Project Name: Mixed use Retail & Residential Building

Project Address: 185 Fore Str.

Site Plan ID Number: # 2014-0660

Memo To: Shukria Wiar
Barbara Barhydt
From: David Margolis-Pineo
Re: 167-185 Fore Street – Review Comments 2014-066
Department of Public Services

(F) BARRIER FREE RAMP DETAILS
N.T.S.

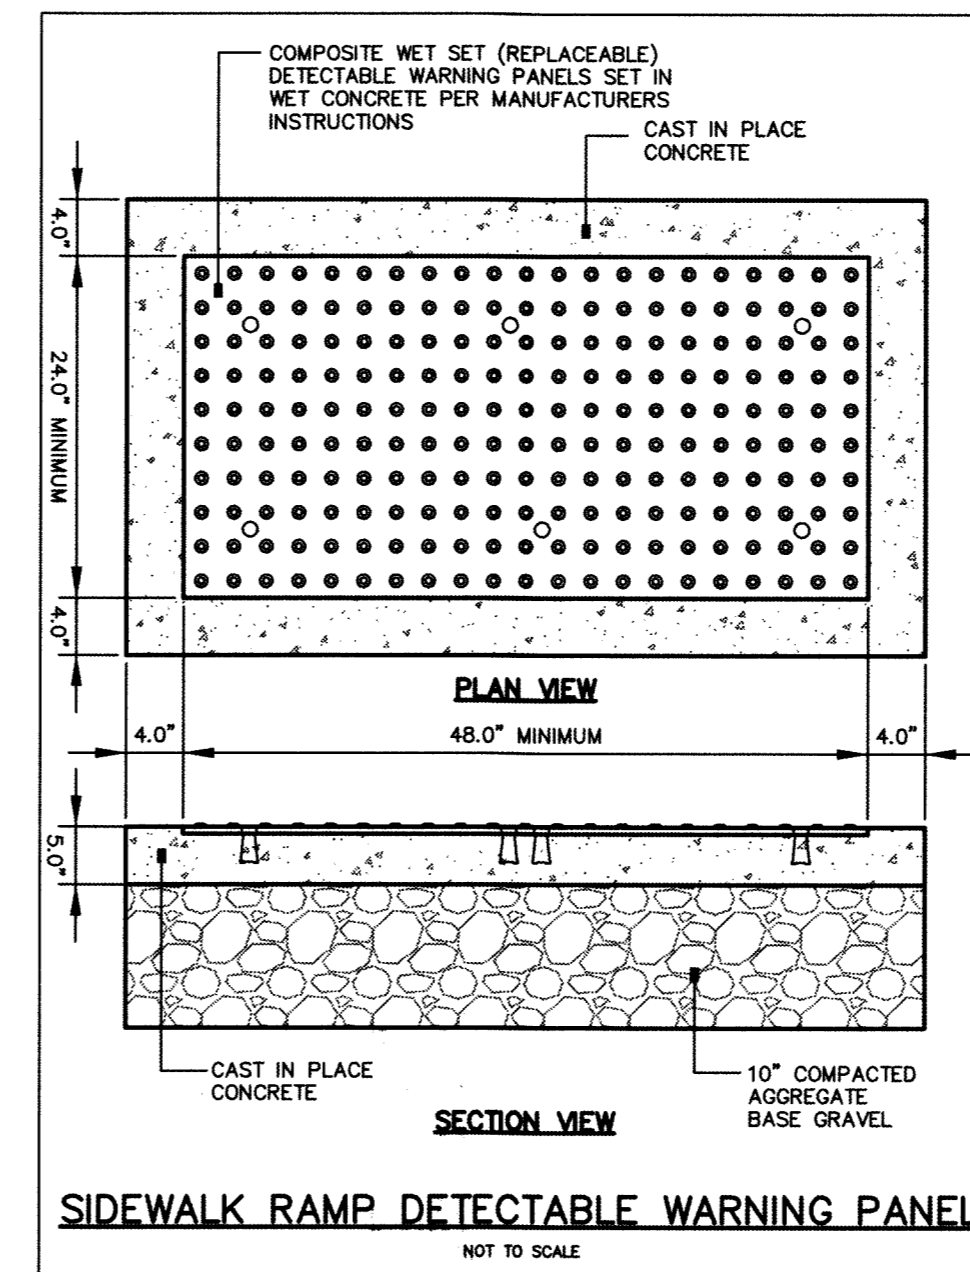
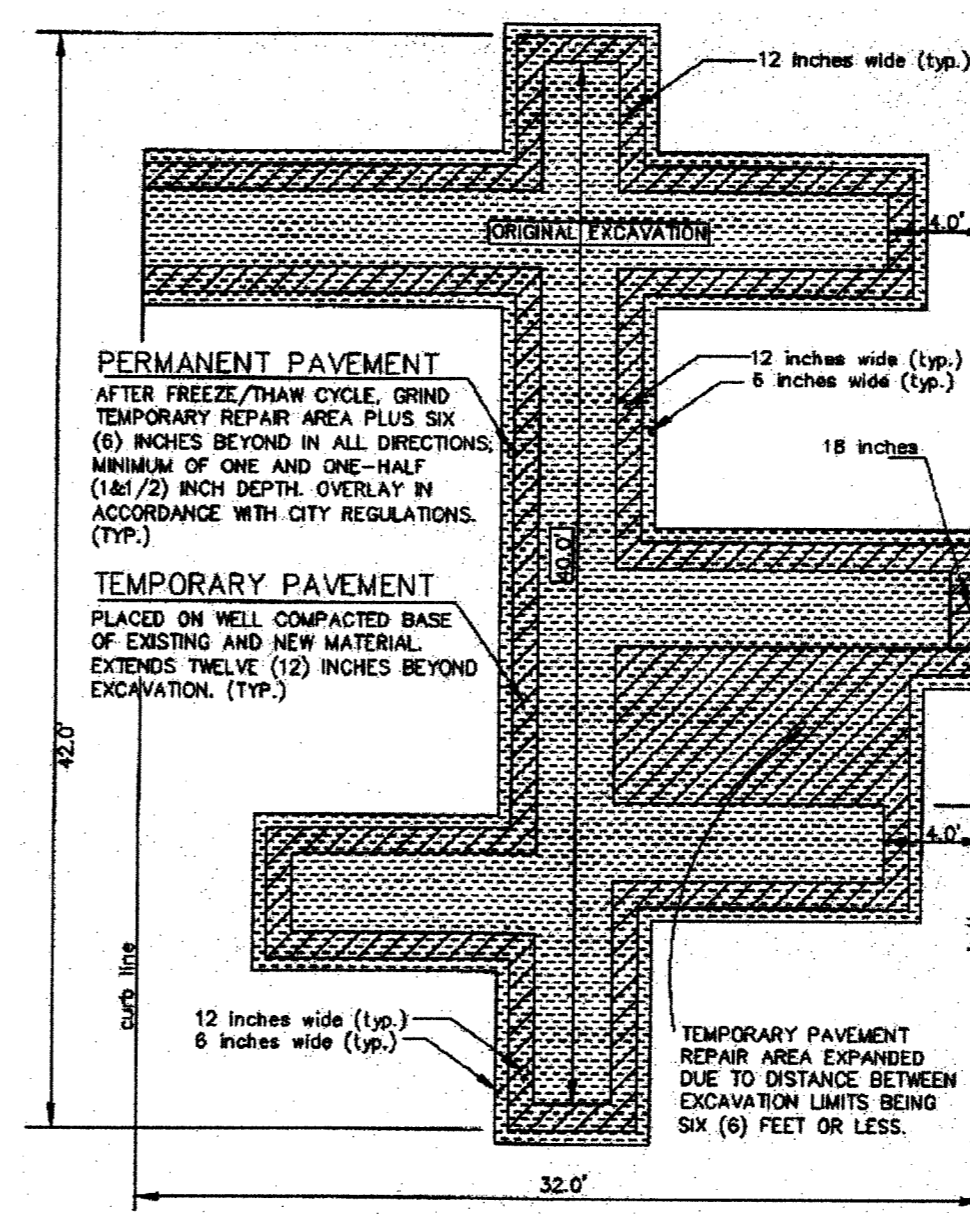
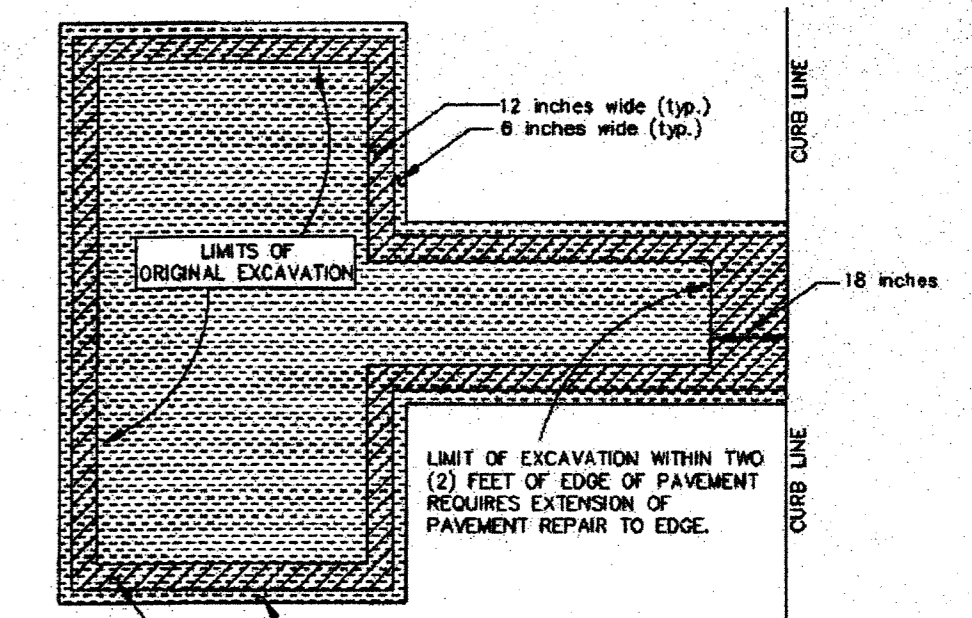
6. All proposed sidewalk crossing ramps shall be constructed to be ADA compliant.

I'm not convinced that the ramp and landing area on the North side of the Fore Street crosswalk has an adequate landing ramp. I am asking Bruce Hyman to further review.

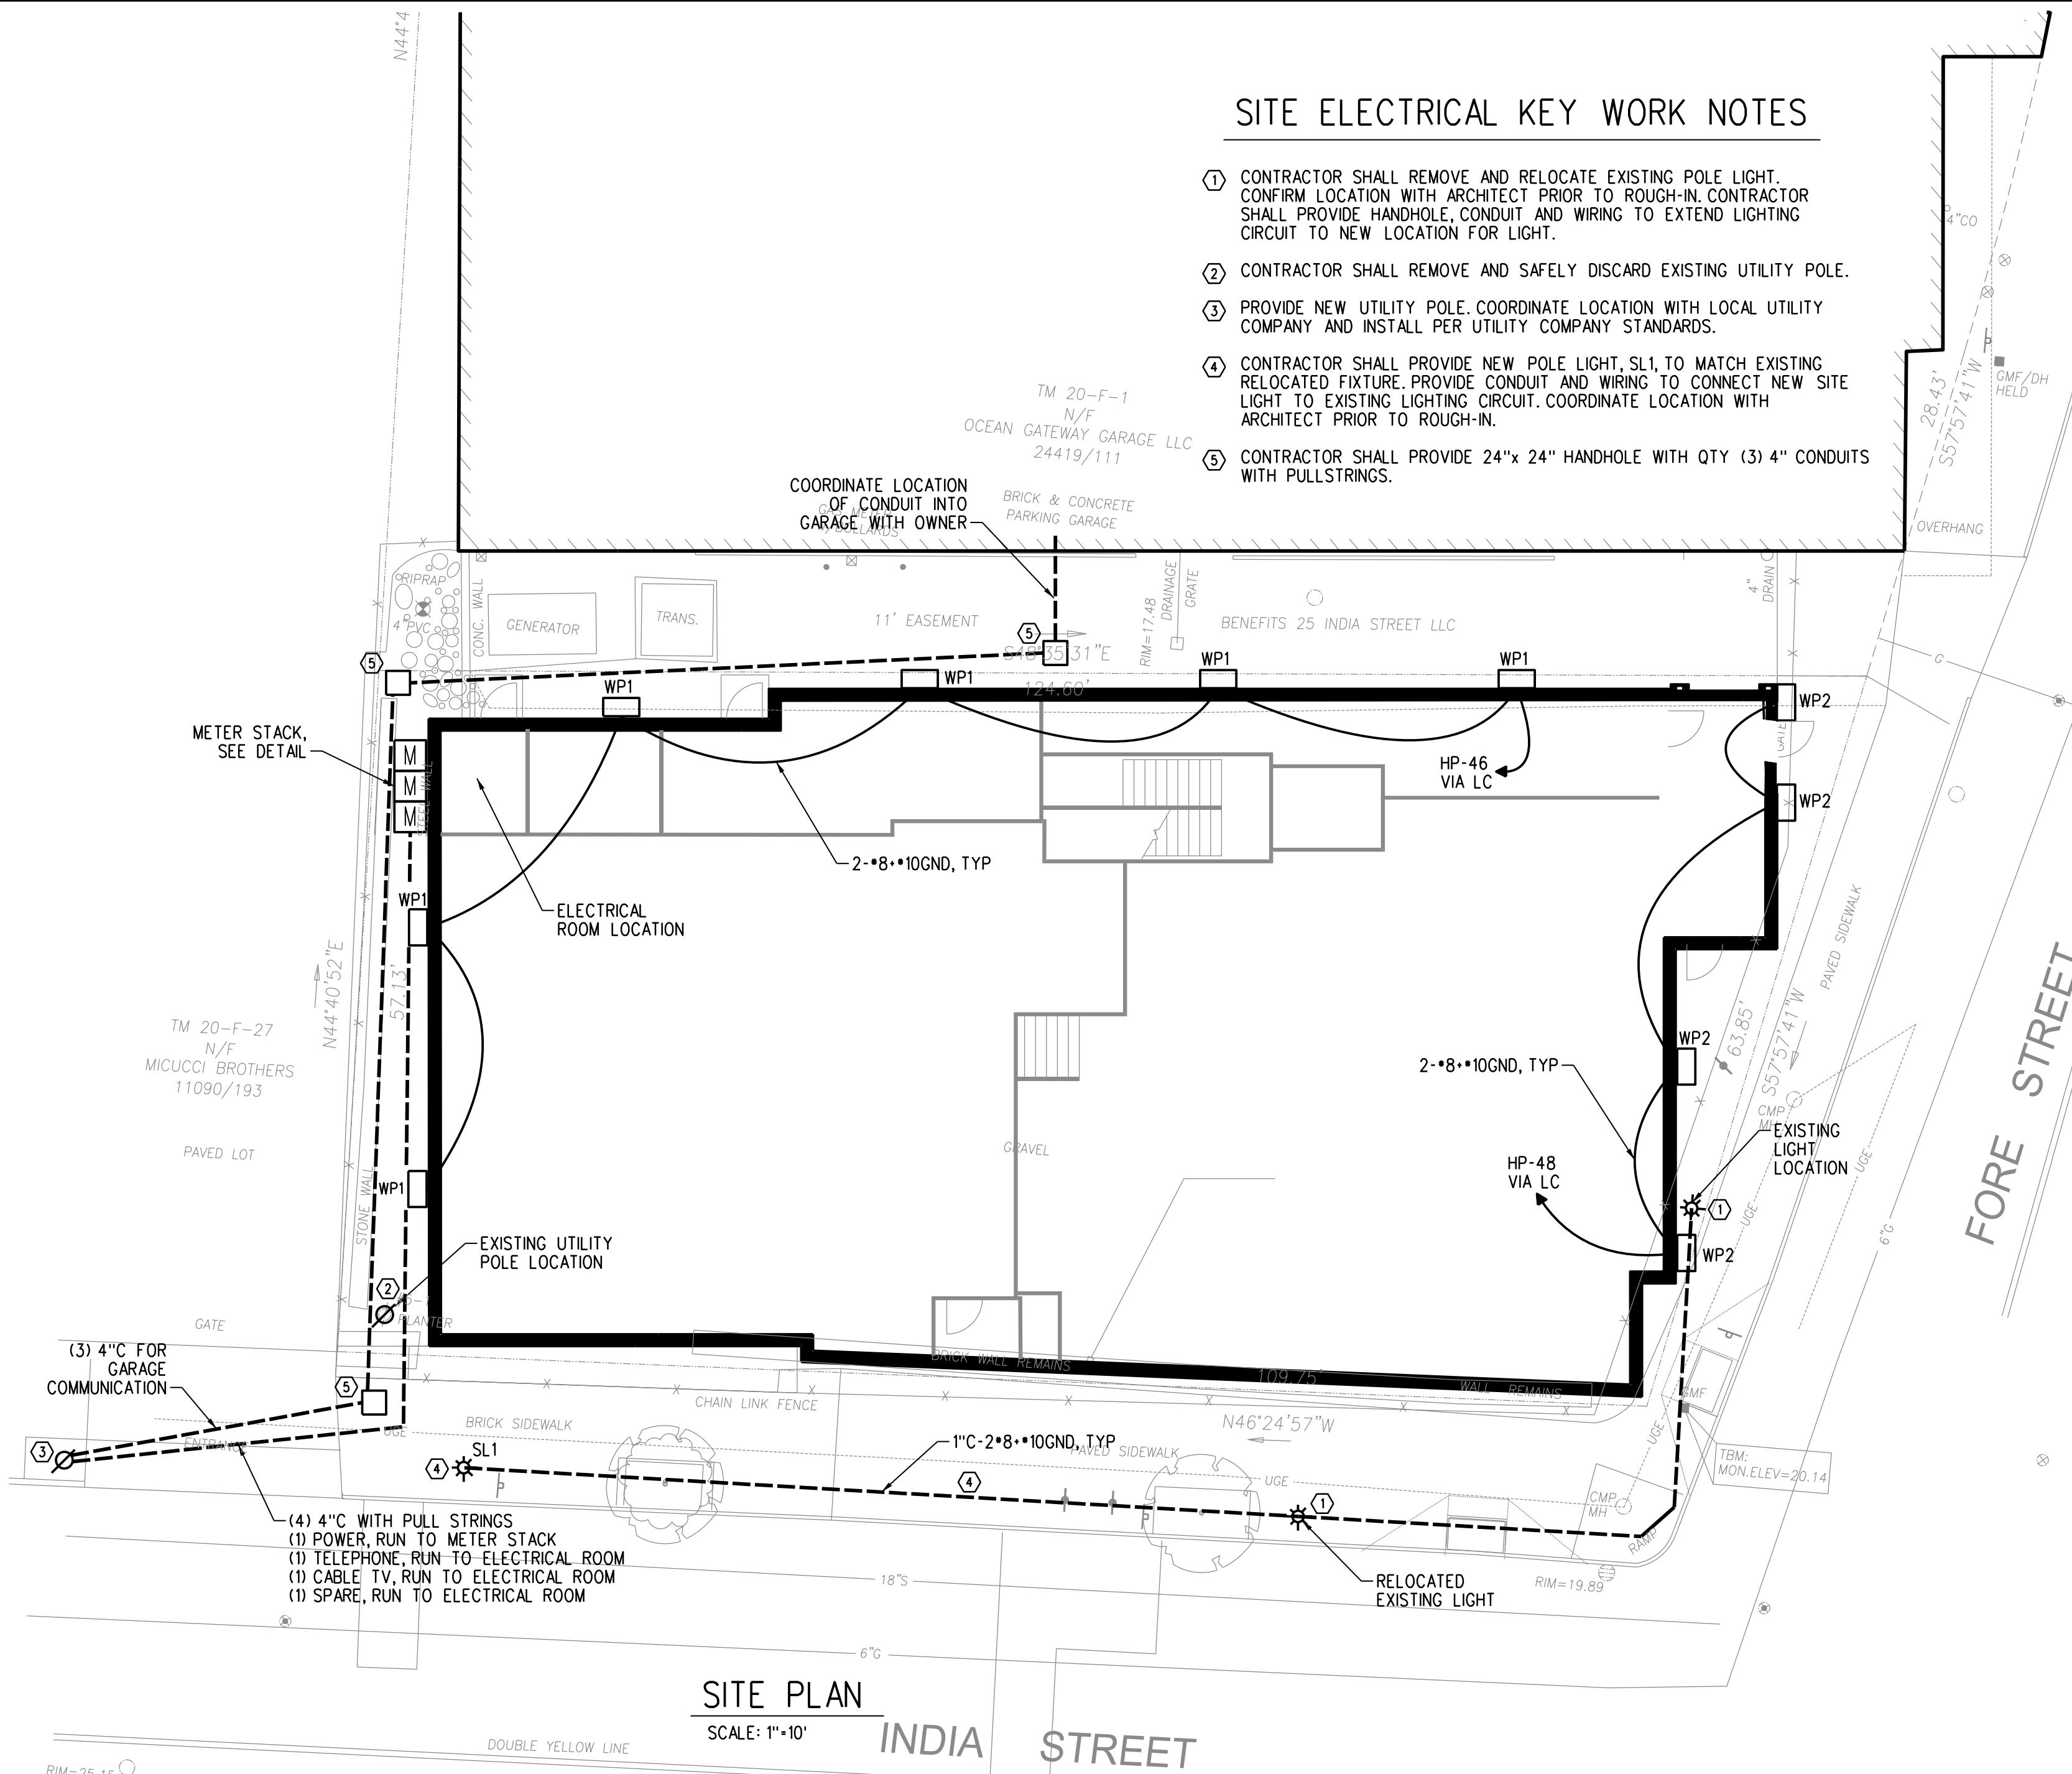
9. Sheet E1.01 shows an eight inch roof connection to the 18" sewer in the street. Sheet C4.0 shows this connection into a catchbasin. Please delete connection on Sheet E1.01.

Correction made.
